Harnett County Government Complex
307 Cornelius Harnett Boulevard
Lillington, NC 27546

RE: Harnett County Existing Tank Application # 08-5-21093

Based on the criteria set out in Title 15A, Subchapter 18A, of the North Carolina Administrative Code, Rules .1950, the evaluation indicated that the site is **UNSUITABLE** for the addition requested. Therefore, your request for an existing tank is **DENIED**. The site is denied based on the following:

12x14 Storage Build

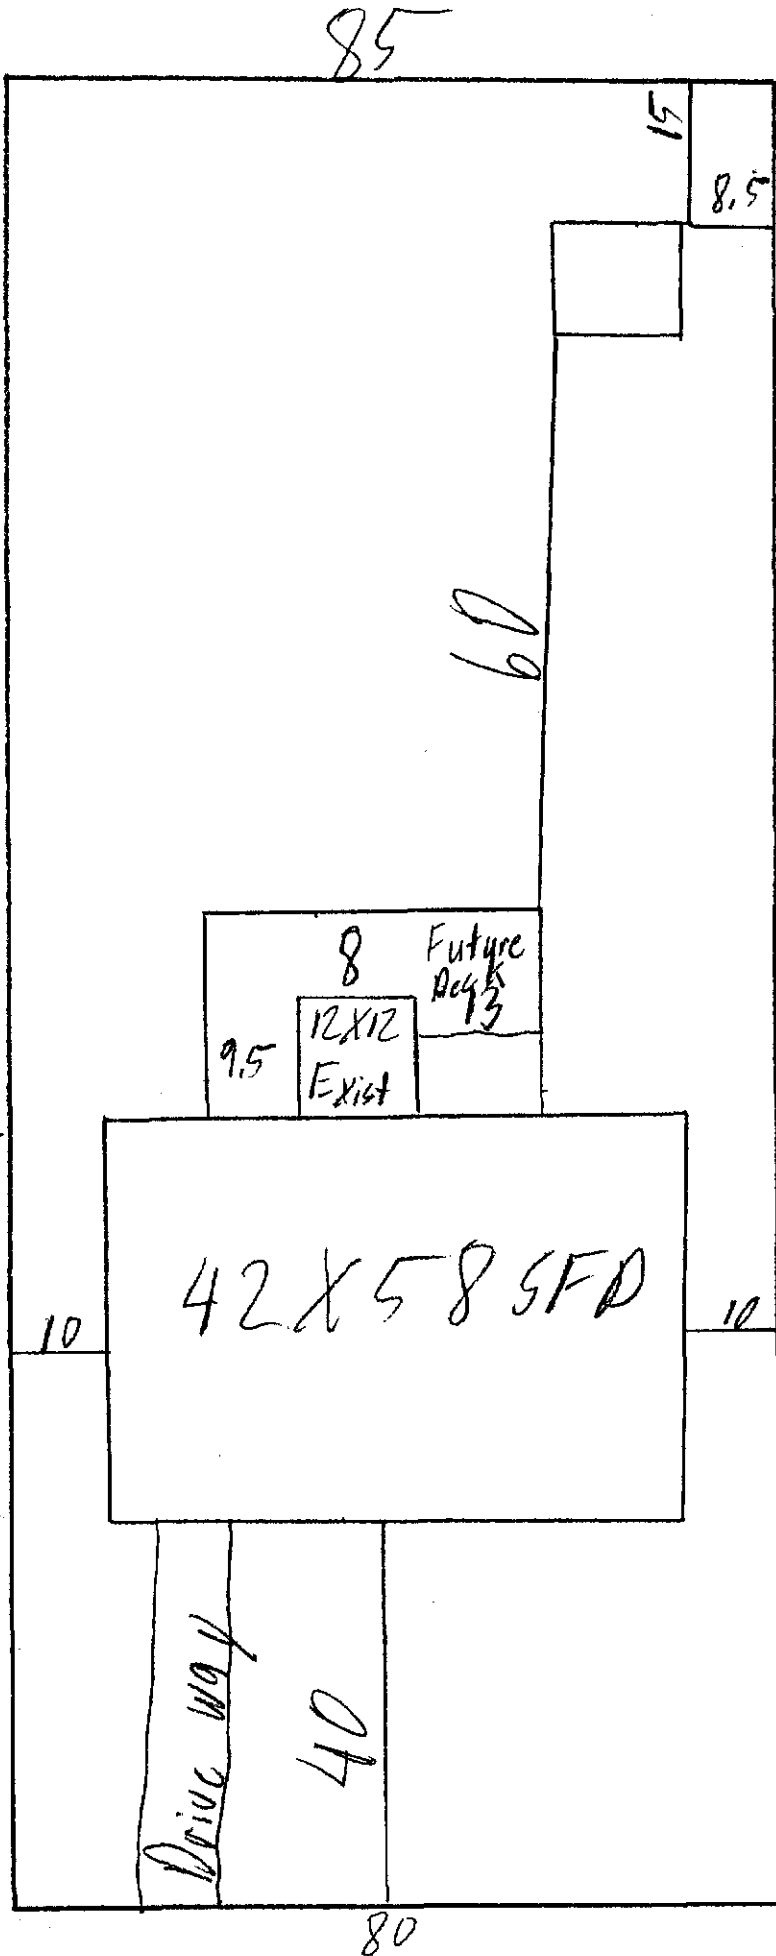
- 15A NCAC 18A.1950 a(16) Any swimming pool must be 15' from any part of septic system.
- 15A NCAC 18.1945 (b) Each lot shall have original septic system plus repair area.
- 15A NCAC 18A.1950 (10) – Any building to be 5' from drain line.
